From: [REDACTED]
Sent: 25 July 2014 08:33
To: Simon Davis
Subject: FAO Simon Davis - Proposed Stable Building - Land to the East of: Orchard End, Highground Lane, Barnham, West Sussex. PO22 0BU - BN/23/14/PL

Re - Proposed Stable Building - Land to the East of: Orchard End, Highground Lane, Barnham, West Sussex. PO22 0BU - BN/23/14/PL

Site Plan at 1:500 scale

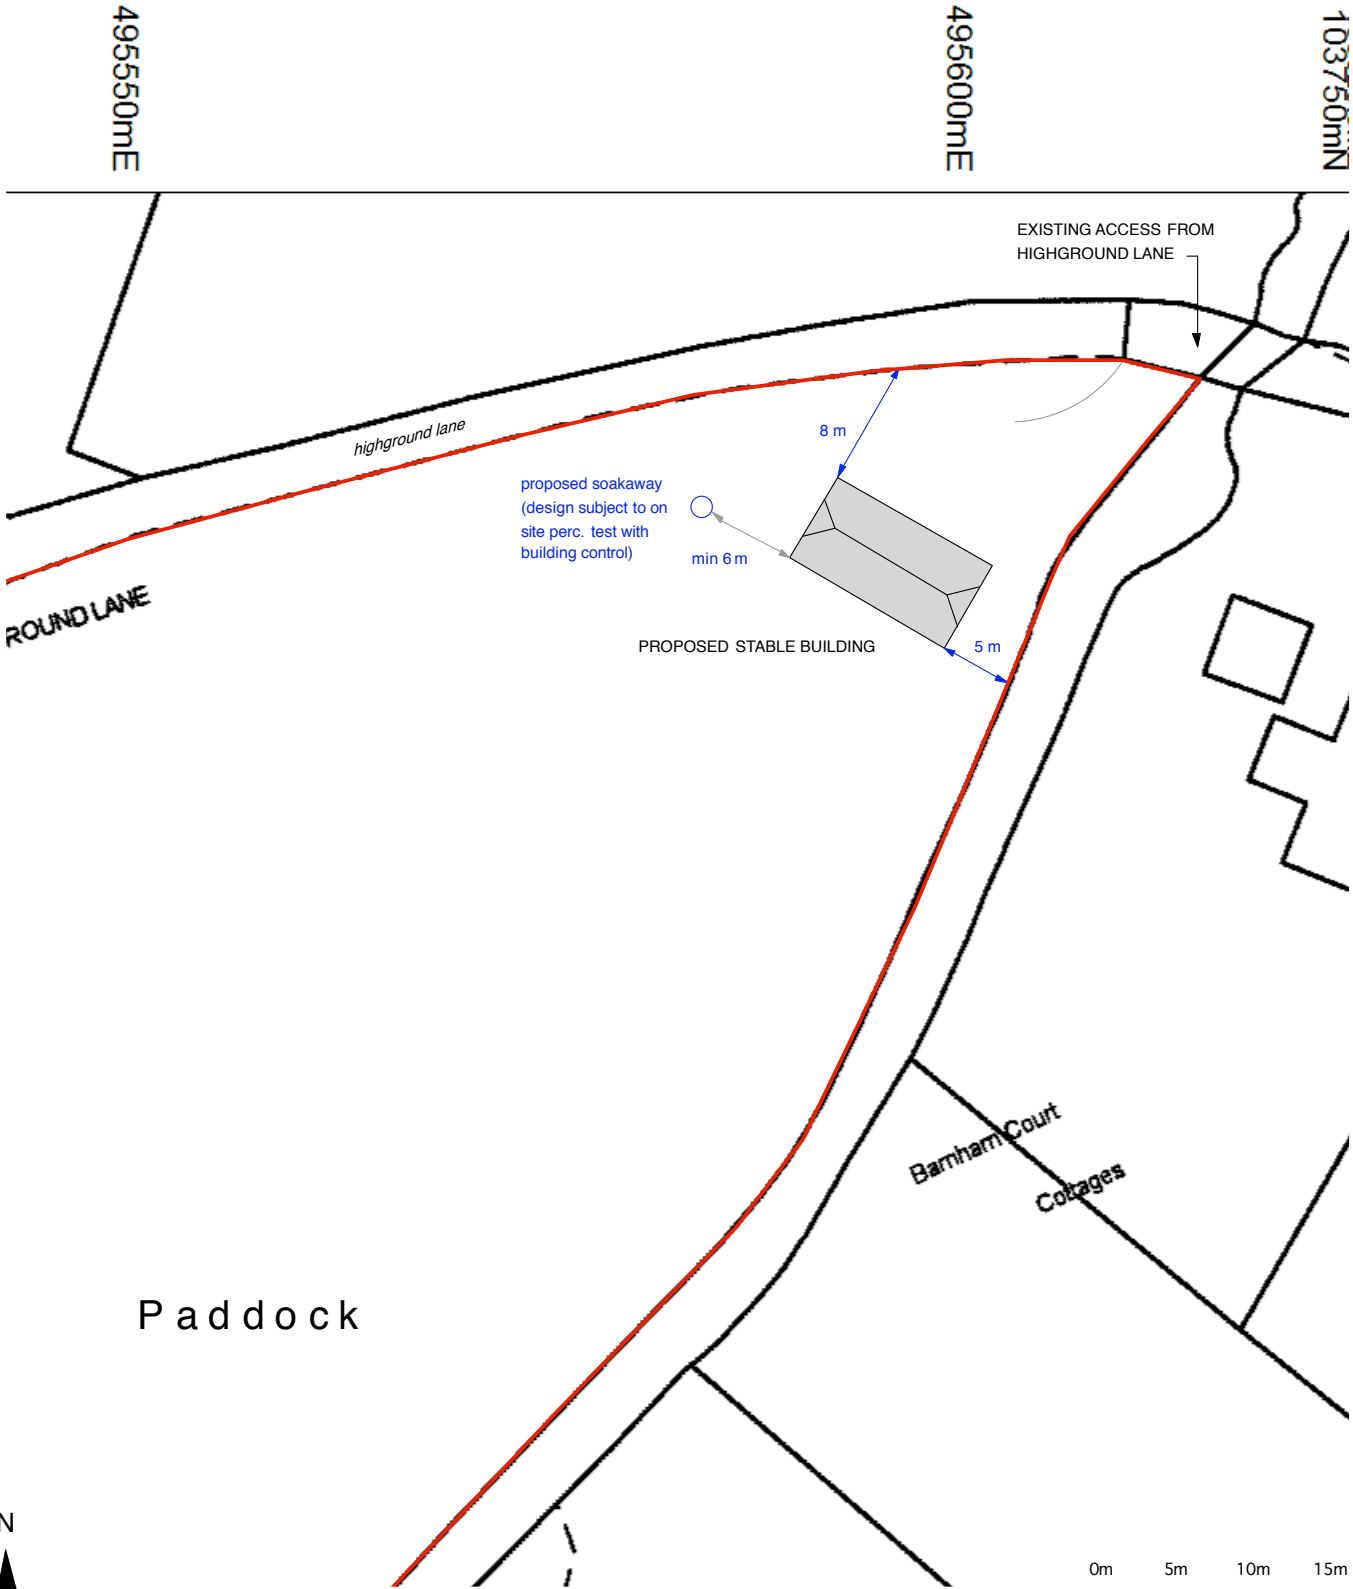
We will resubmit next week with the proposed stable building rotated to avoid building over southern water foul drains.

No objections have been raised so far to the application. I am yet to make a thorough assessment (and I cannot advise when that will be) but the only concern I had whilst on site was the location of the building in a part of the site where there is no screening etc. If I decide I need to refuse I will try to let you know beforehand.
